Nov. 29th 2021

To: Amber Willard Planning Officer Arun District Council

I am writing in response to the application to Y/154/21/HH and Y155/21/HH, in relation to a proposed alteration to an outbuilding for accommodation for an annex, to Hobbs Farmhouse, Bilsham Rd., Yapton, West Sussex, BN18 OJY.

PROPOSED SIDE ELEVATION AT 1:100 SCALE

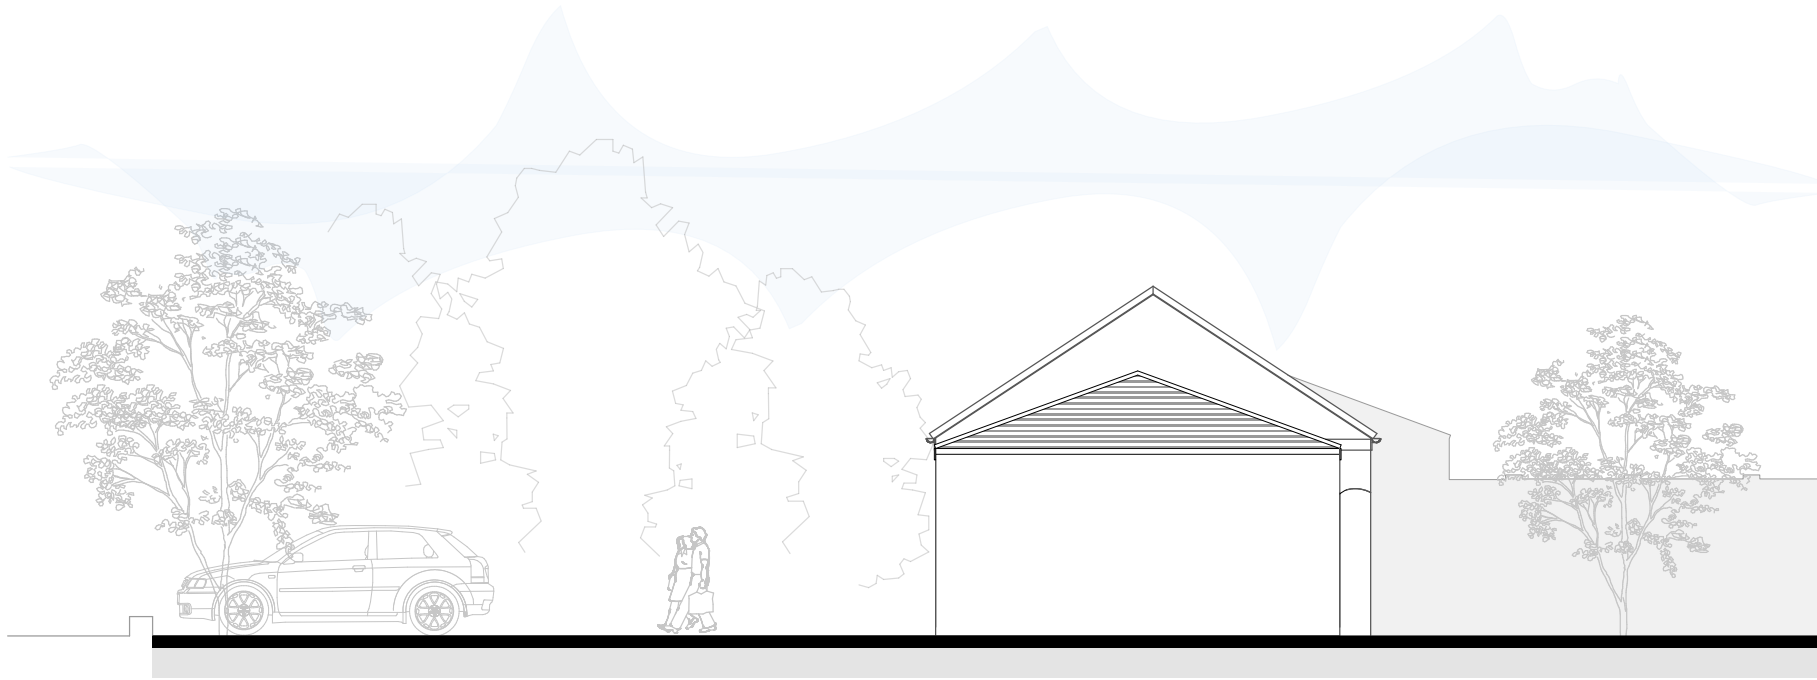
f) Presently there is a beech hedge screening the existing outbuilding structure from view from my property. Full height windows/doors are shown to the Northern elevation of the annex and facing my property. There is no indication that the existing beech hedge is intended to remain as screening. It is requested that it is required to remain, if the proposal is to be approved otherwise.

g) Any windows/ glass doors in a Northern elevation would impact on my property and privacy. It would be significantly exposed by any such addition without constraint otherwise from its present status. I.e., the retention of the beech hedge in front of them to obviate this.

Site Plan at 1:500 scale

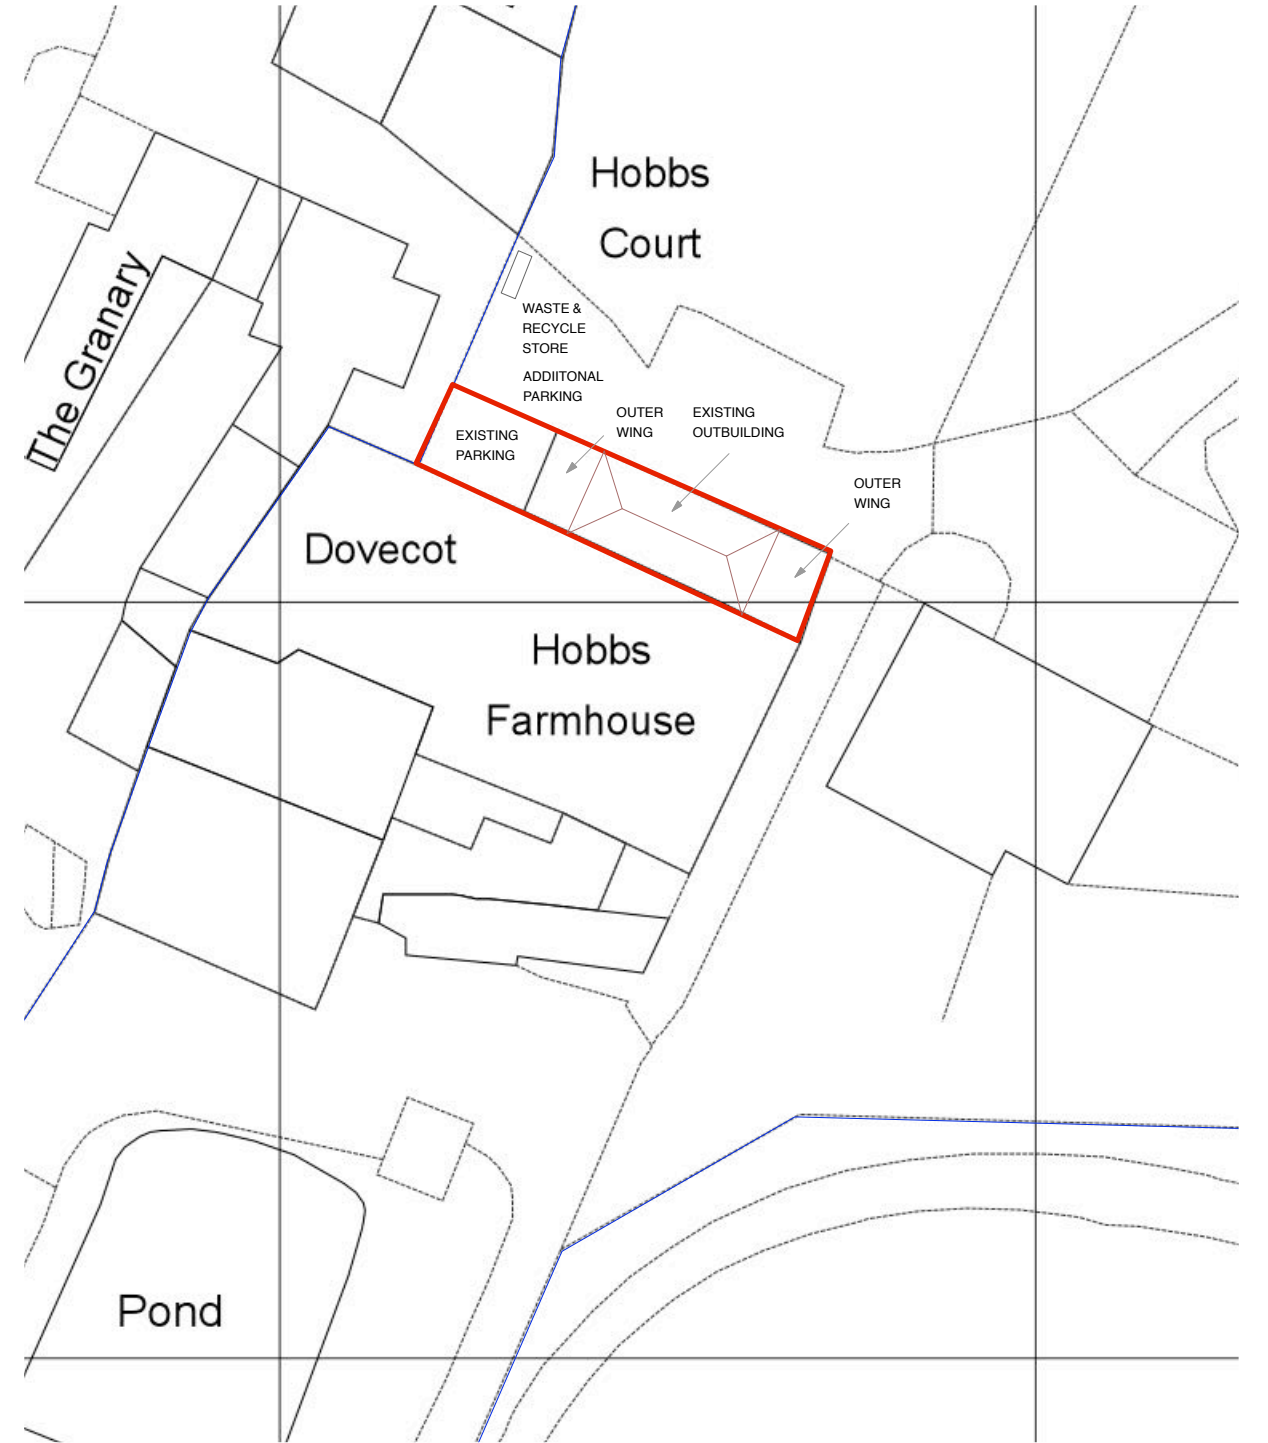
- a) The block plan submitted is outdated, (allegedly approx.15years) and not allegedly representational, of the area around the Farmhouse and Hobbs Court as it is today. Also, in relation to existing neighbouring properties, in context and setting, and giving an allegedly misleading impression instead.

- b) It is also unexplained, why such an outdated block plan would be submitted with the proposal, allegedly indicating that it is current when it is not. It is representational of the pre- development of Hobbs Court and surrounds instead. Up- to- date and confirming details are understood to be readily available from Land Registry and deeds. (O.S not always current).

- c) It is observed that my own property is indicated in the plan merely as '5,'and shown in its pre-development stage footprint. At that time, it was a lean- to derelict pigsty in a field. The plan presented, indicated this is still its present status, and as if not relevant, regarding the present proposal in result. As records will confirm, it was converted to an 'L' shaped domestic dwelling and purchased in March 016.

d) Also noted by way of alleged exclusion now, the absence of its proper name and present status as, 'The Potting Barn', and as if not included in Hobbs Court at all at this time (the other properties are all named and recognised in the plan). By way of correction, my property is confirmed as being part of Hobbs Court for approx. 5 and a half years. It is also noted that Hobbs Court also stretches North as well as to the West to include it, but as only referred to in the latter way in the proposal details.

Also absent from the block plan and in Hobbs Court, is the additional new build 5 bay garage block also constructed at the time of the development of the site and should be shown adjacent to the long side of the 'L'-shape of my property. If any form of 'setting,' is submitted in details of Hobbs Court, it would seem necessary for it to be fully representational of the present.

e) In the area shown above Dovecote in the plan it states, 'Hobbs Court', as if in the 'grounds' of the Farmhouse, which is incorrect. Hobbs Court is in the area to the West and North and where the other properties are named. The 'driveway' in the plan is also incorrectly configured and allegedly appearing to indicate that it goes into the Farmhouse land but the former no longer exists in that location.

g) Towards the Southeast of the block plan, outbuildings are indicated. Excluded from the block plan, but also present, and not far from the large modern barn, which is referenced to the East of the proposed annex, is a *further* outbuilding to the East, of which more details, later in this document.

f) Also in the block plan, is a definitive blue line, which passes '5' as indicated, and goes further North and then turns to the Northeast. *It is advised that this is the boundary between my own property and that of the Farmhouse.*

Fig 3-4. Front (SW) Elevation & Courtyard & Front (SW) Elevation & Courtyard

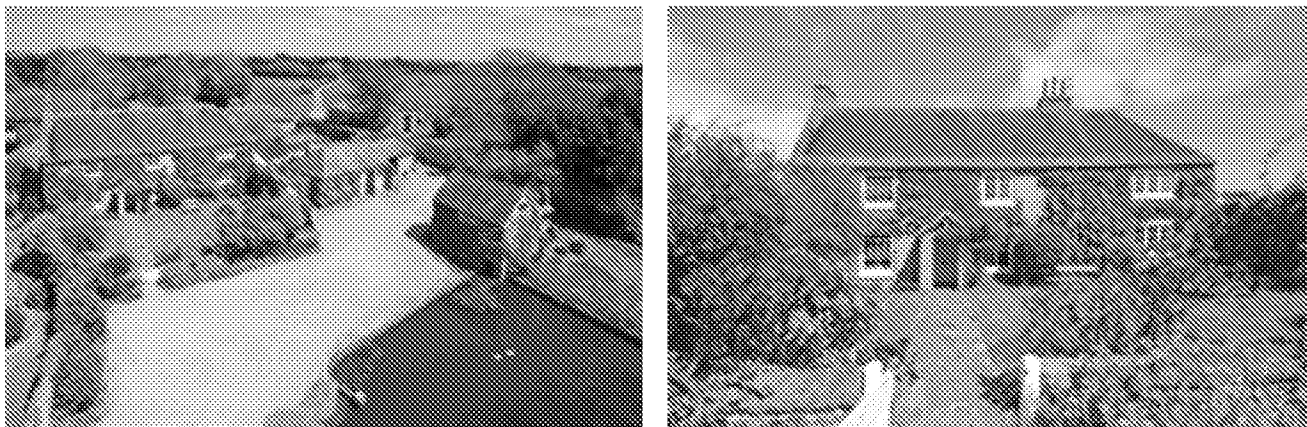
a) The front elevation photographs submitted of the Farmhouse are also allegedly 'historic', (from approx. 30 years ago), and not representational of its present status, which is substantially altered in external view since then. There were no recent photographs of the front elevation and surrounds of it, allegedly unavailable on the website.
